Letter No. **A2/22269/2003**

Sub: CMDA - **Planning Permission - Construction of Ground Floor with one dwelling unit of Residential Building at Plot No.38-B, S.No. 636, "Sri Kamakotti Nagar" Pallikaranai Village - Development Charge and other charges to be remitted - Regarding.**

The Planning Permission Application received in the reference above cited for the construction of Ground Floor with one dwelling unit of Residential Building at the above referred site at Plot No.38-B, Survey No.636, "Sri Kamakotti Nagar" of Pallikaranai Village was examined and found approvable.

CROSS SEC. OF COMPOUND WALL

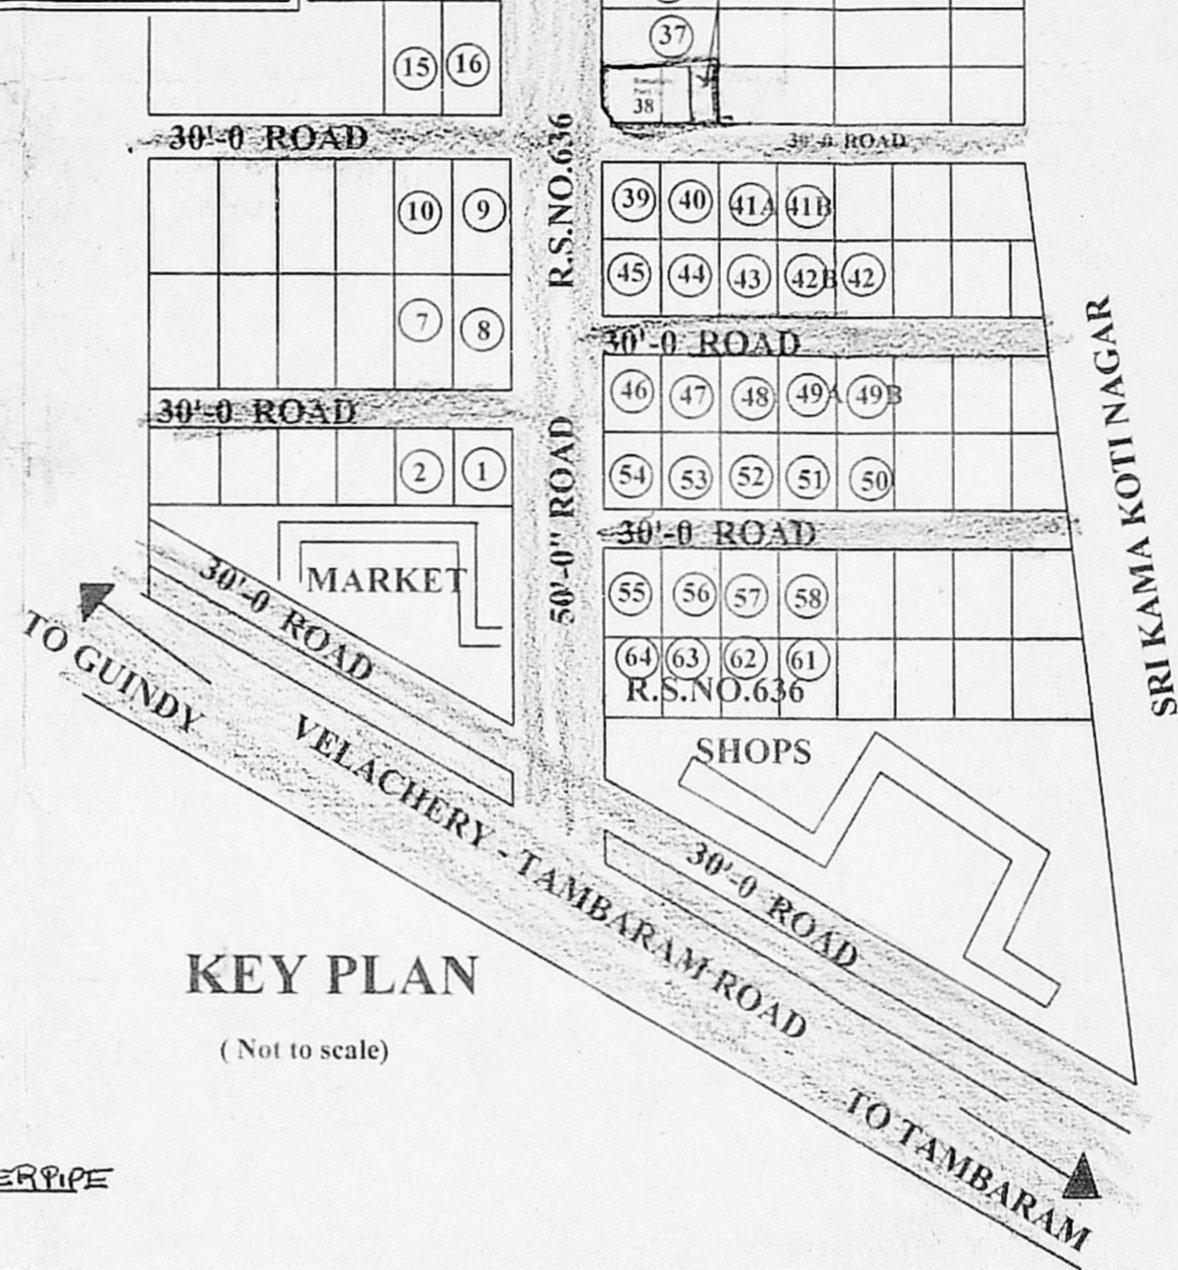
- a) Rain water conservation regulations stipulated by CMDA should be adhered to strictly.
- b) 5 copies of revised plan by
 - i) Showing the terrace floor plan.
 - ii) Showing the cross-section of the compound wall.
 - iii) Providing 7.50cms height of dwarf wall along the gate.
 - iv) Indicating the plot No. 38-B properly in the key plan.
 - v) Mentioning the S.No. as 636 part instead of 636.
 - vi) Showing the Rain Water Harvest as per standards.
- c) Separate Demolition plan for existing A/C sheet alongwith demolition deed.
